From: Tim Rainbird [REDACTED]
Sent: 07 September 2017 12:04
To: Simon Davis; Tom Woolner
Cc: Paul Cann
Subject: RE: BE/71/17/PL - Wickes, Bognor Drainage Scheme

Comments;

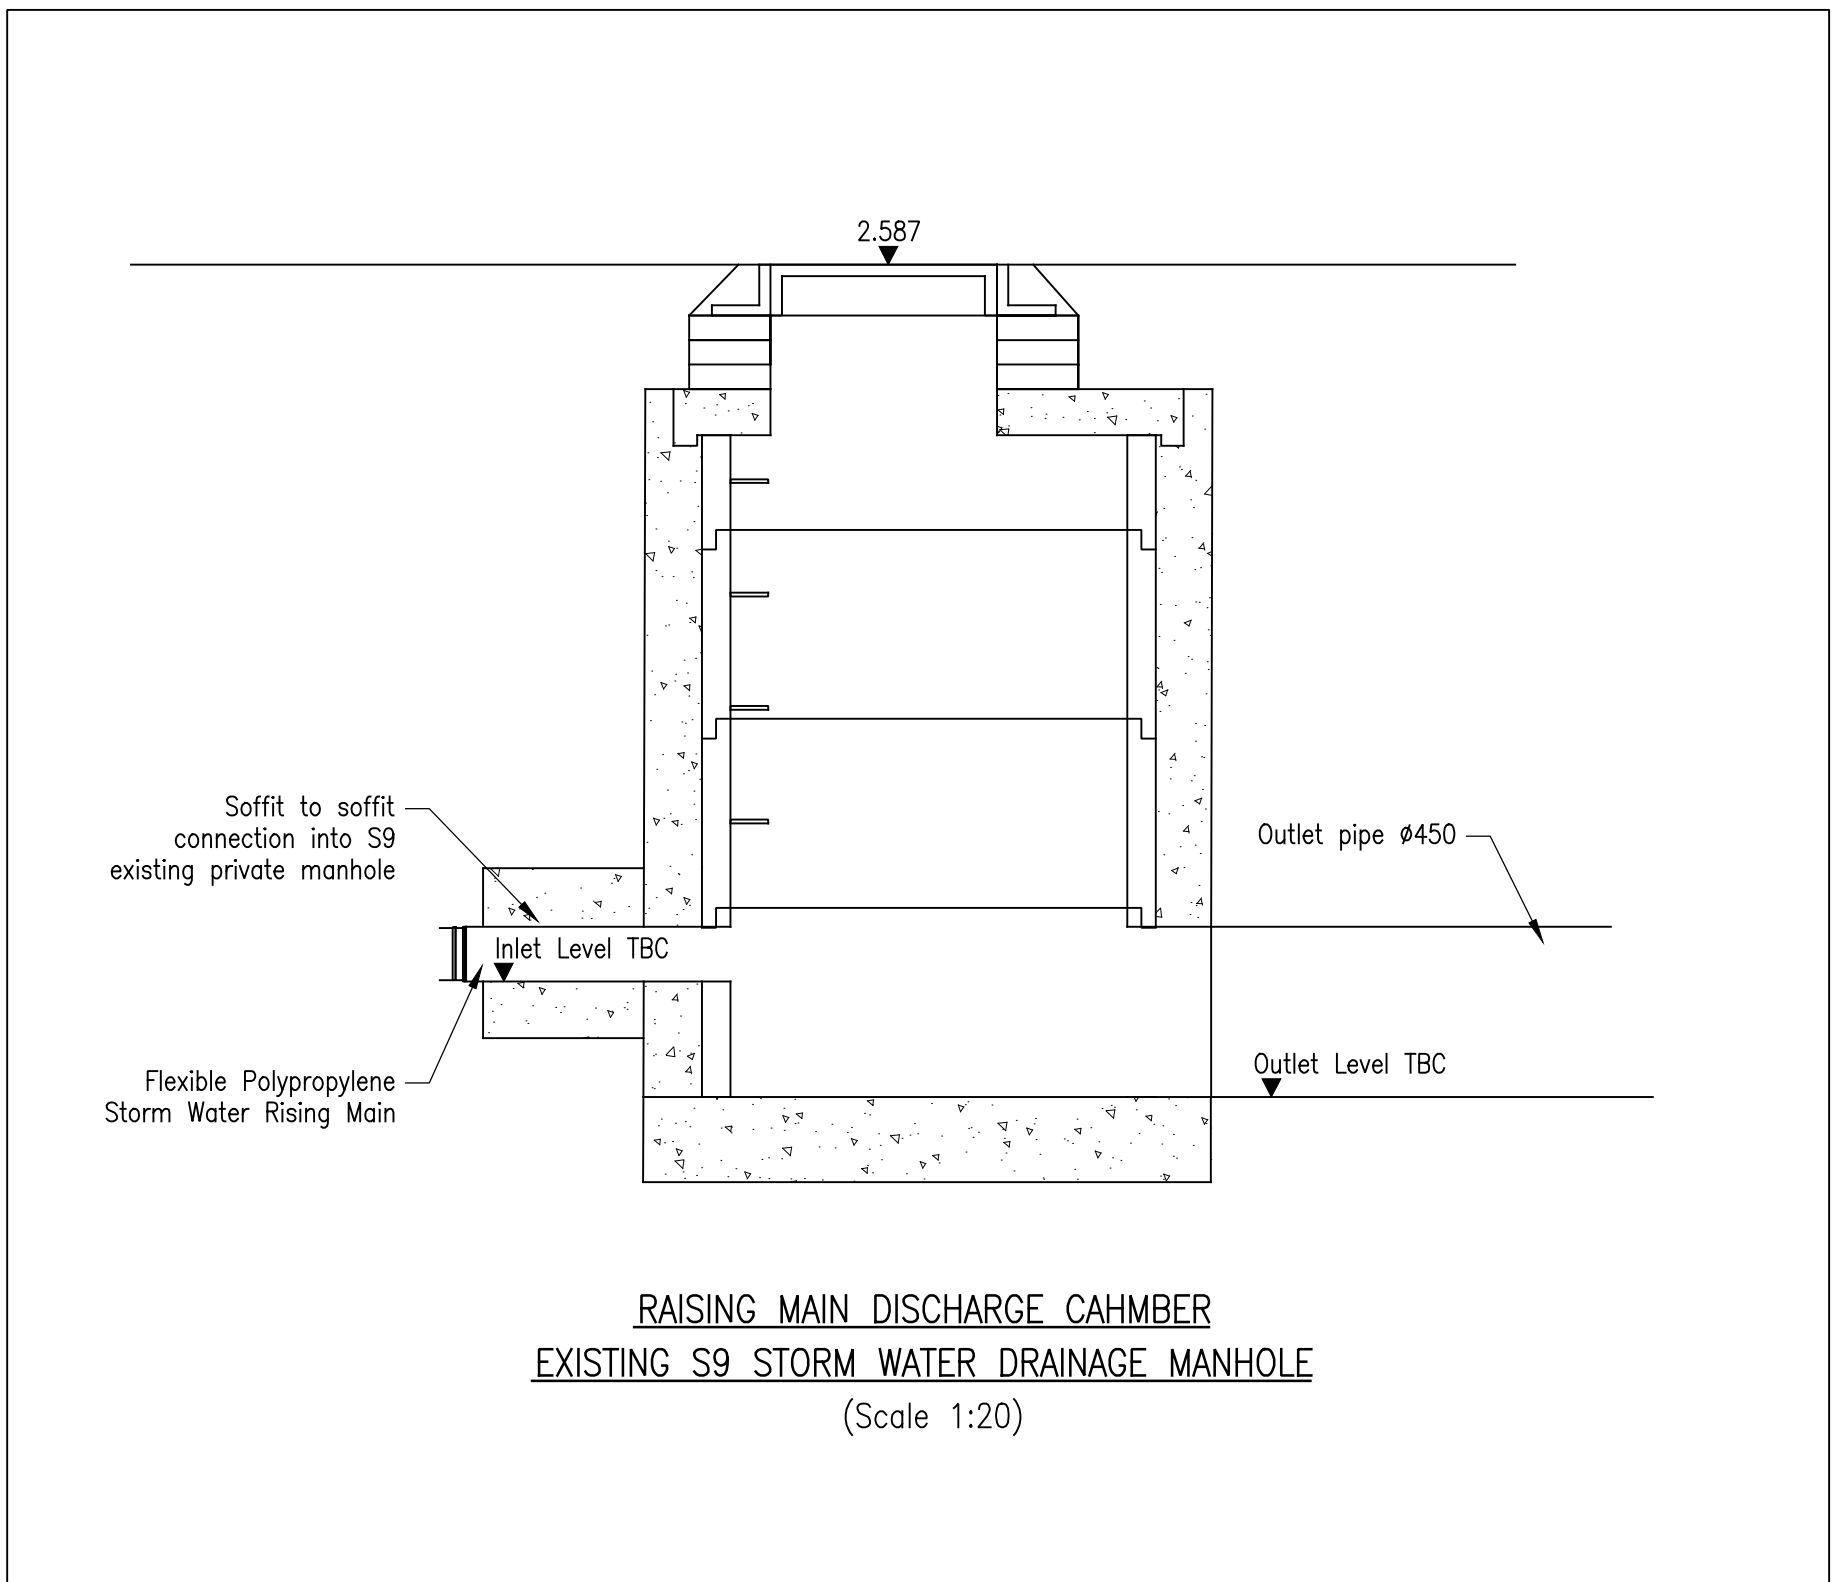
1. Full construction details of the pumping station and rising main. This will also need to include pipe bedding details, thrust block details and discharge chamber details.
2. Malfunction alarm details for the pumping station.
3. Pump manufacturers design/spec.
4. A maintenance plan for the future operation/maintenance of the pumping station.

It is important that the pipework configuration is considered carefully within the discharge chamber to ensure the smooth transition of flows. This will need to be detailed.

1. Full construction details of the pumping station and rising main. This will also need to include pipe bedding details, thrust block details and discharge chamber details.

Typical details are on the attached drawing 15-112/500

| <b>15-112 / 500</b> | <b>P3</b> |

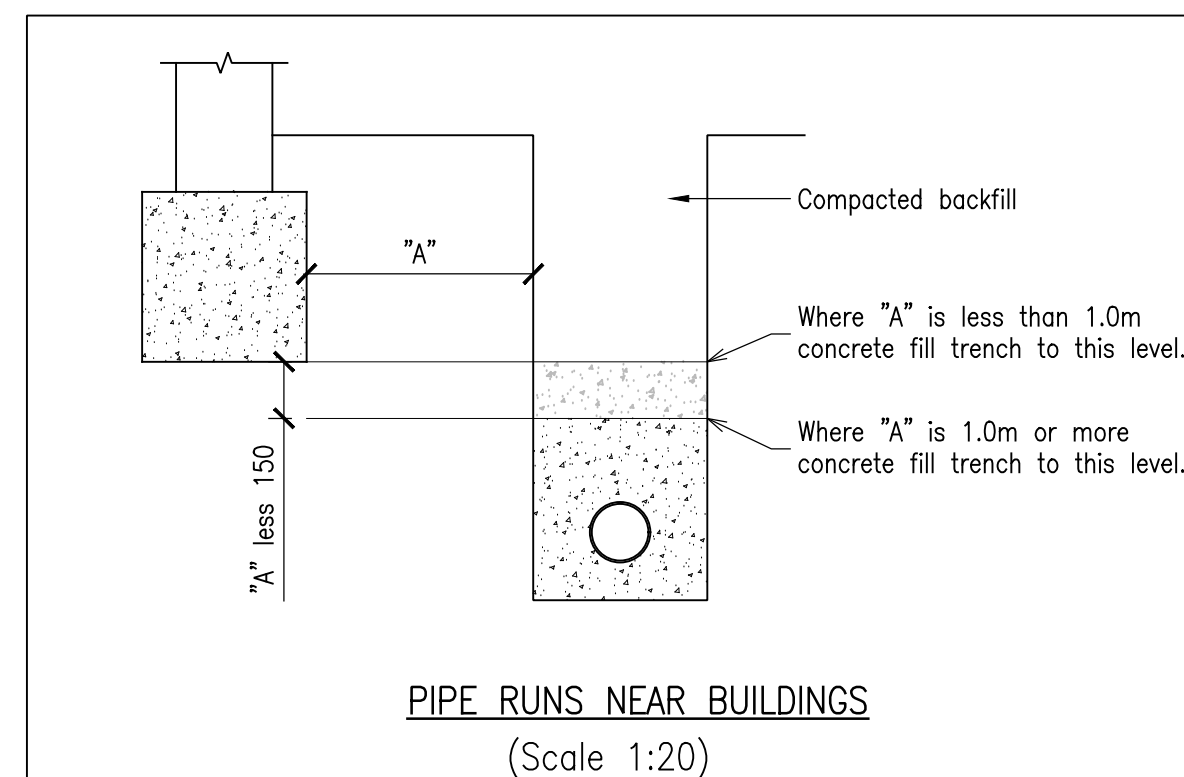
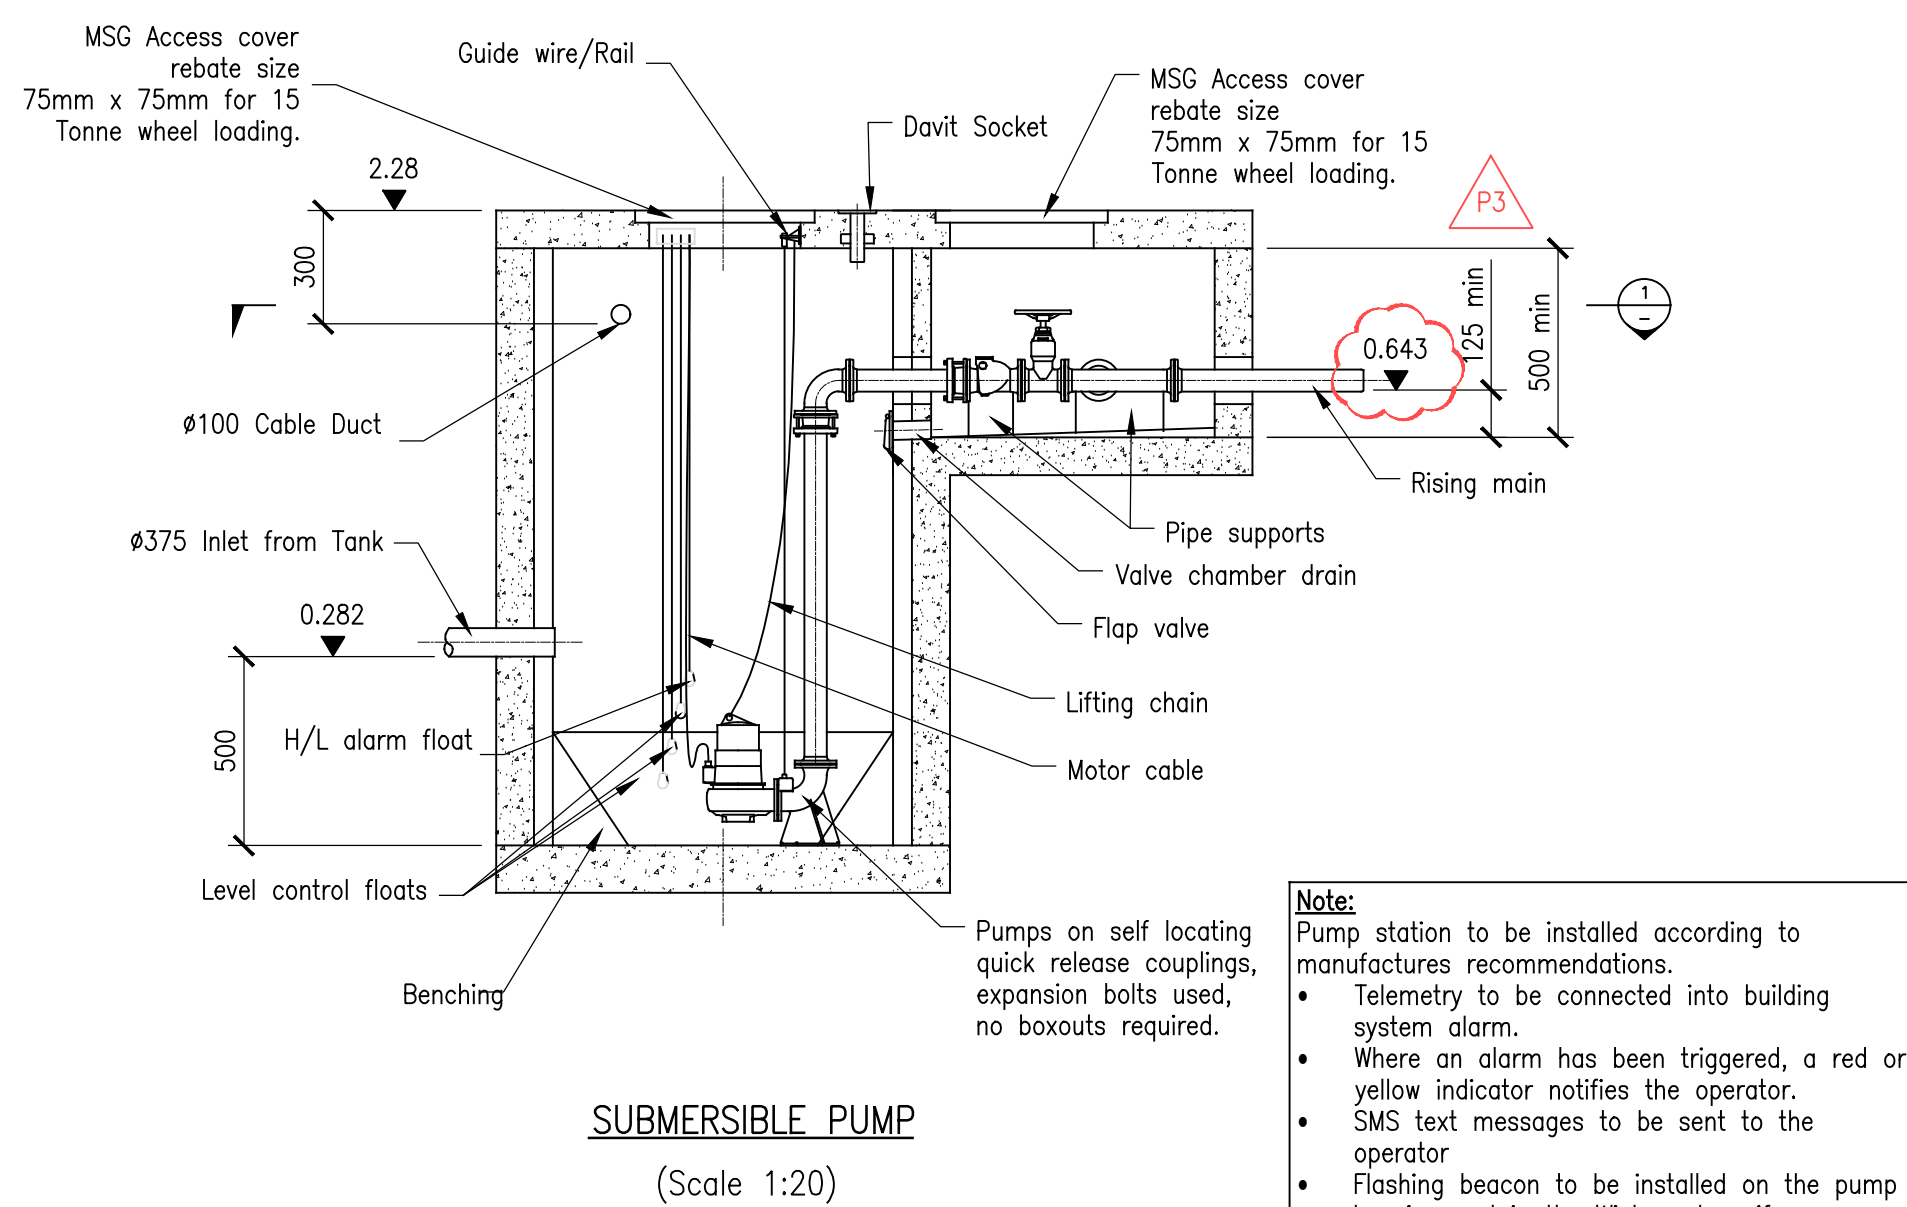
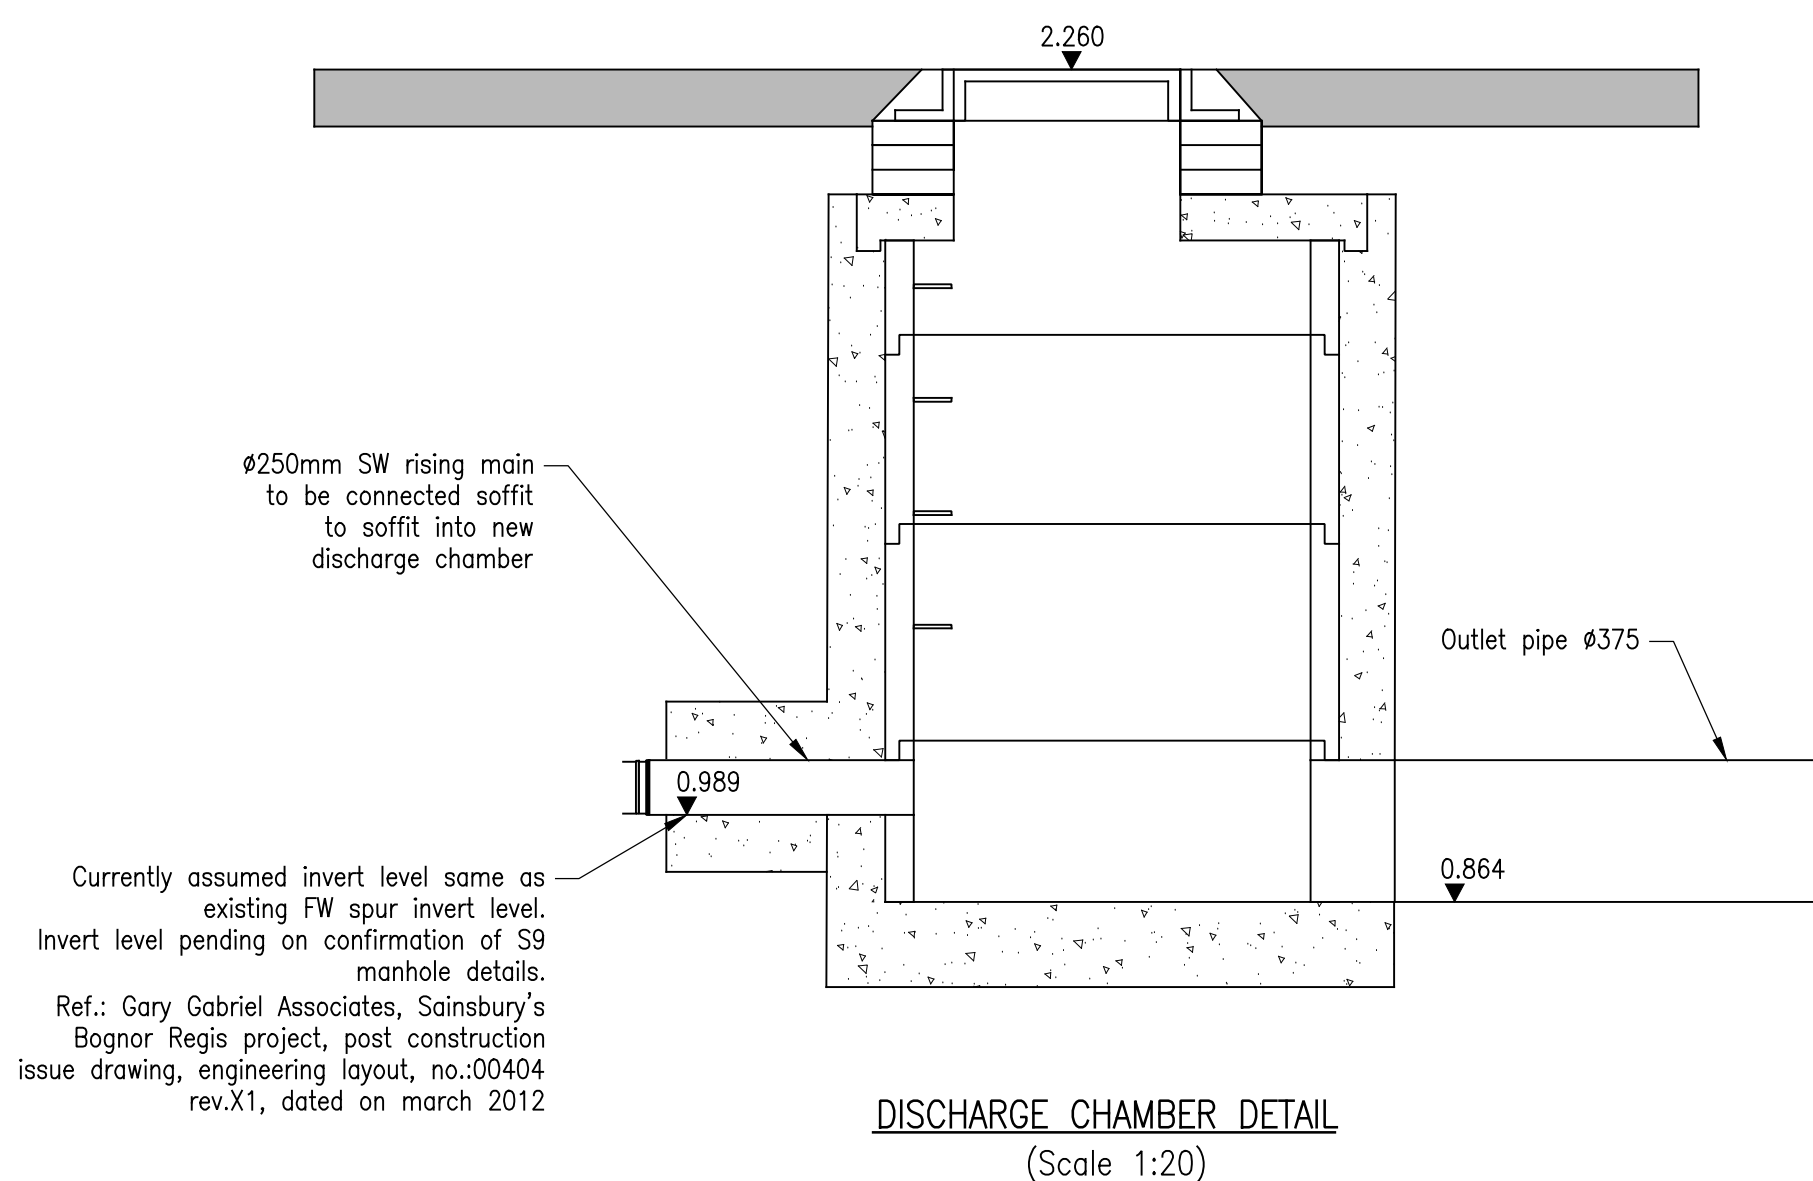
1. As the proposed connection is to manhole S9 on the Sainsbury's system, the proposed drainage layout plan needs to be amended accordingly, as the connection is currently shown to manhole S10.1. The rising main needs to discharge into a discharge chamber say min. 10m away from manhole S9, so that flows can dissipate as much as possible and reduce disruption to the main flow in the 450mm pipe. The gravity length of pipe between S9 and the discharge chamber should be laid at a minimal gradient but still achieve self-cleansing velocity. Please amend the drawings/construction details accordingly.
2. Please specify as to the arrangement in case of an alarm ie. are text messages automatically sent to nominated persons, etc/flashing beacon on station?
